RFI

RFI #: 217
Date: 1/3/2013
Job: EB-02 Keller Springs Lofts
Phone: 877-777-5115

Subject: Details needed for concrete pole base

Drawing: 1C,2C, E-10.1
Cost Impact: None

SHEET
 2C OF 9

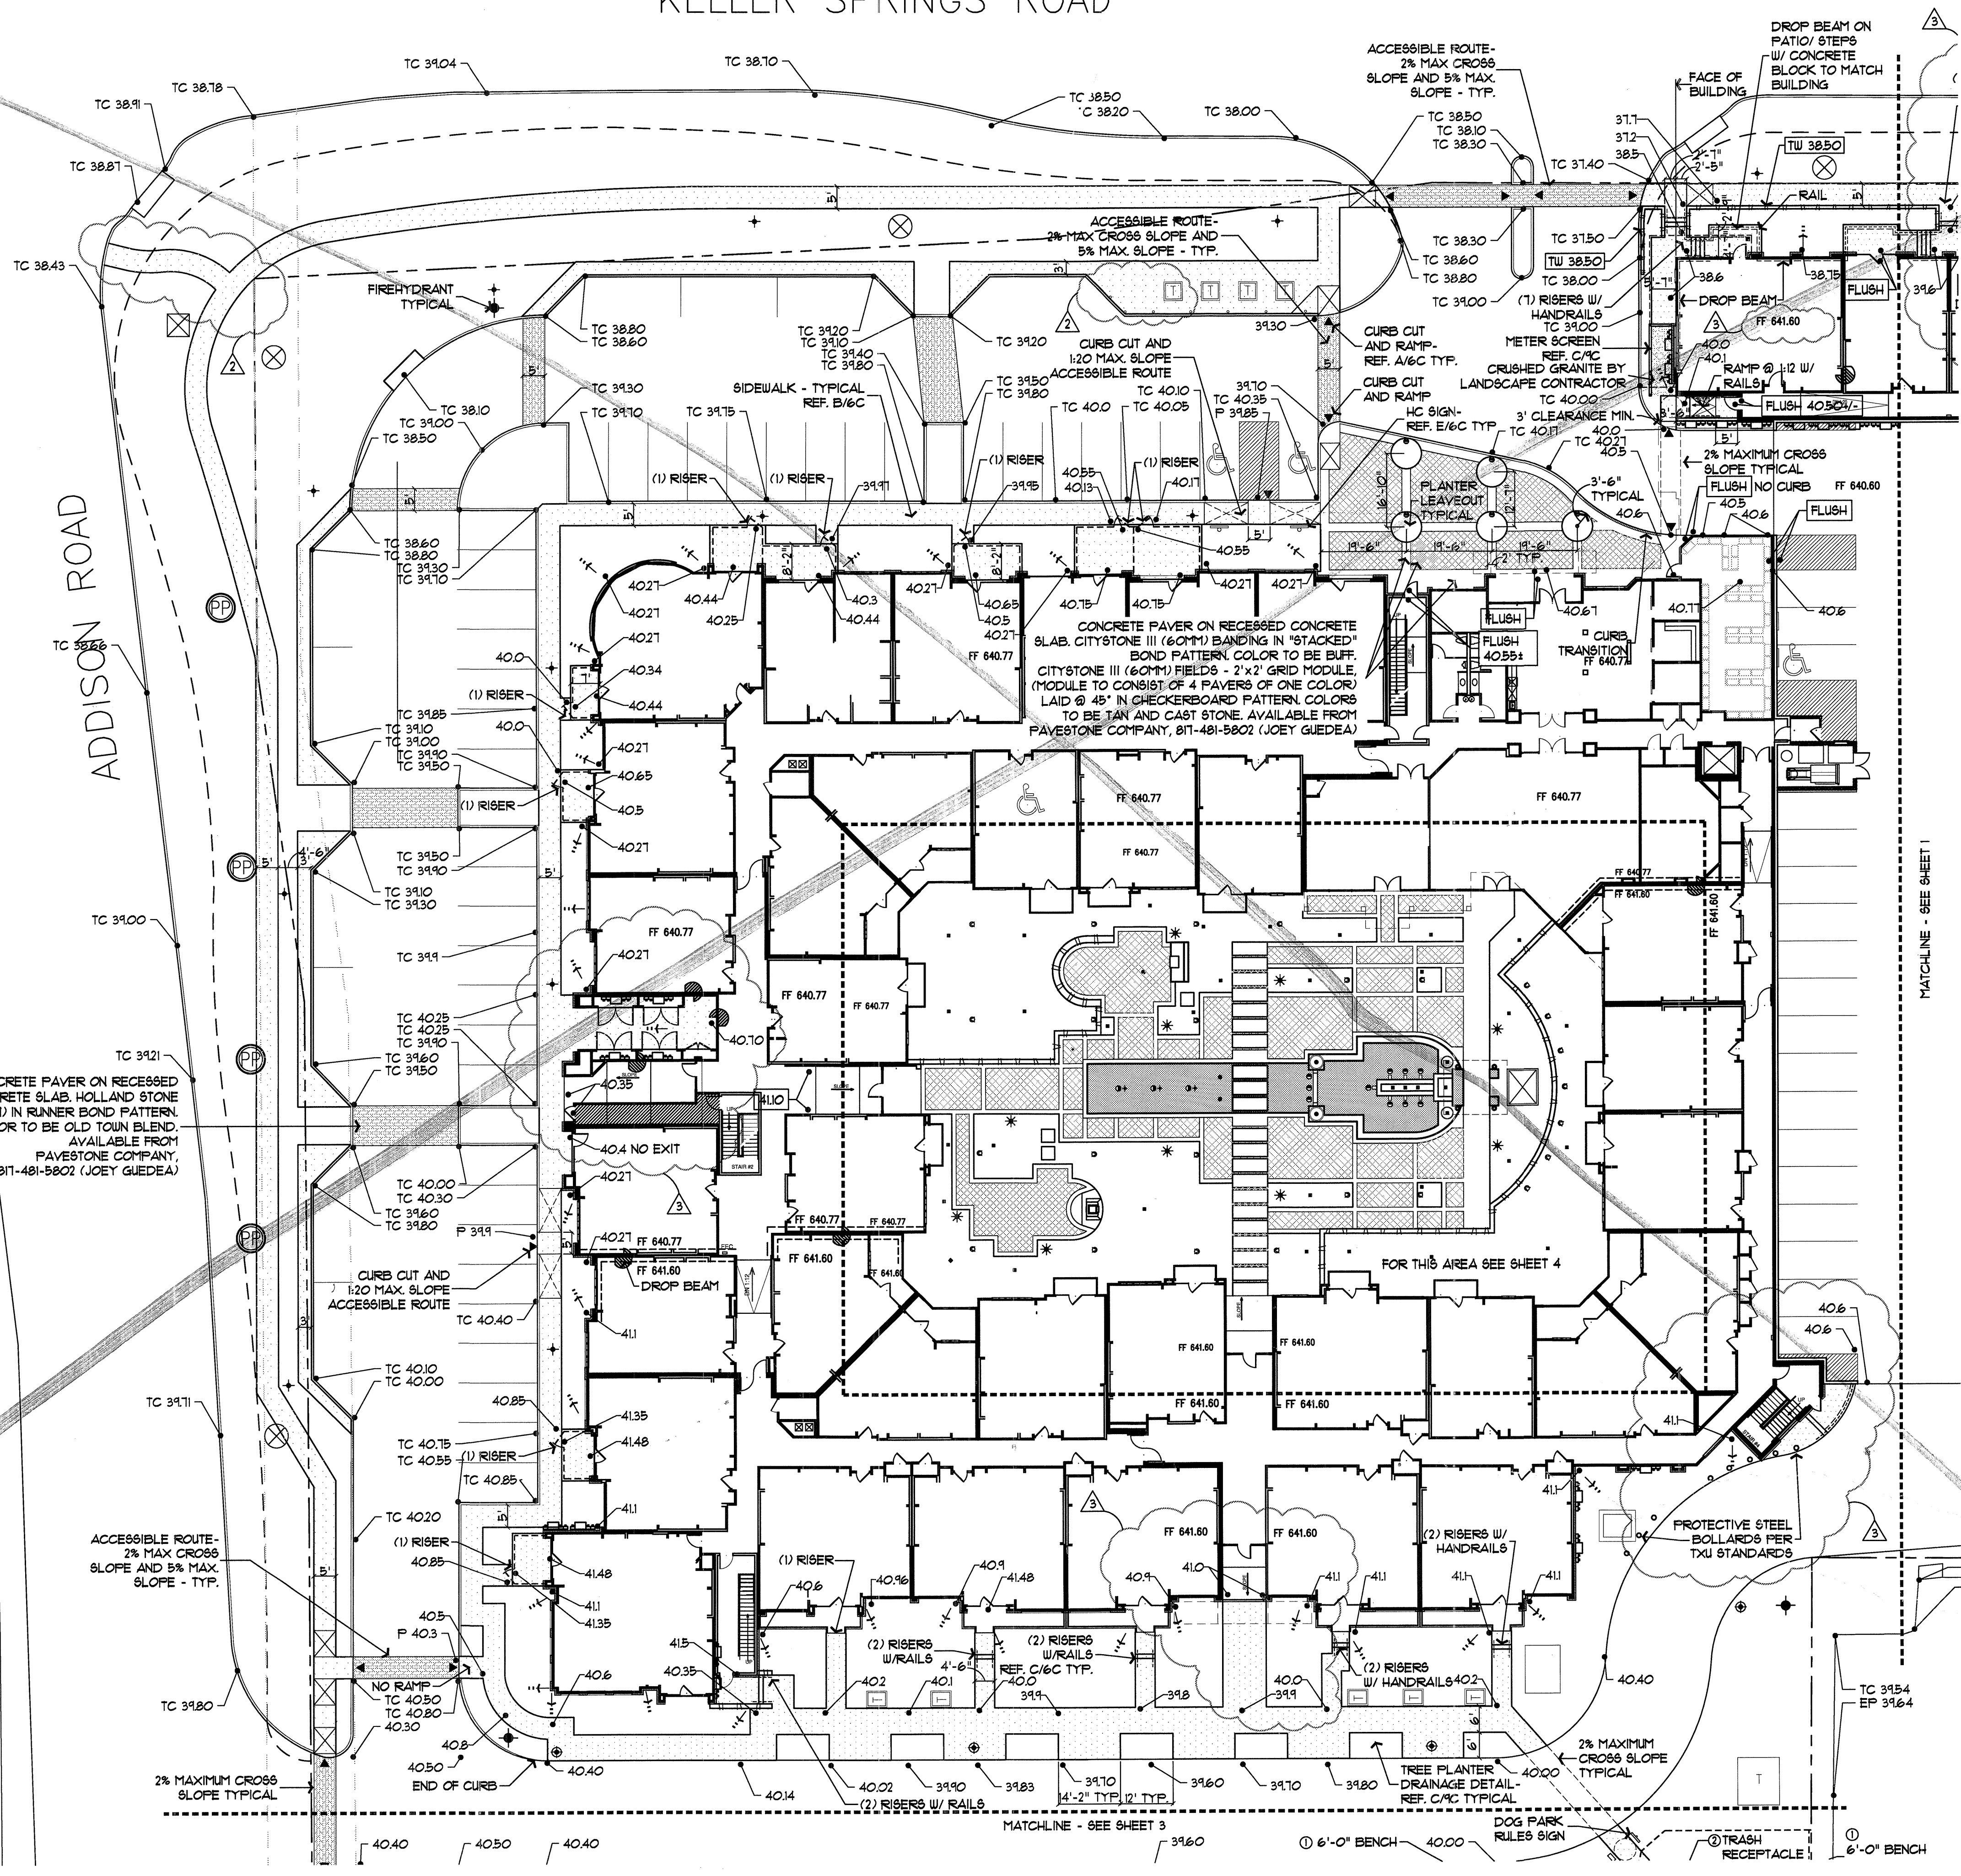
Request: Date Required: 1/26/2012
 Landscape sheet 2C needs to be coordinated and revised to reflect the revised paving elevations on revised civil sheet C4 (1/17/11). There are areas of conflict of up to 1' between drawings.

Response:
 Attached please find the following sheets with the revised grades as coordinated with the Civil and Architect:
 Construction sheets 2C, 3C, 7C;
 Partial breezeway plan prepared by BGO;
 Landscape sheets 2L, 3L, 4L;
 Irrigation sheet 2S
 RFI 45 is incorporated in these plans
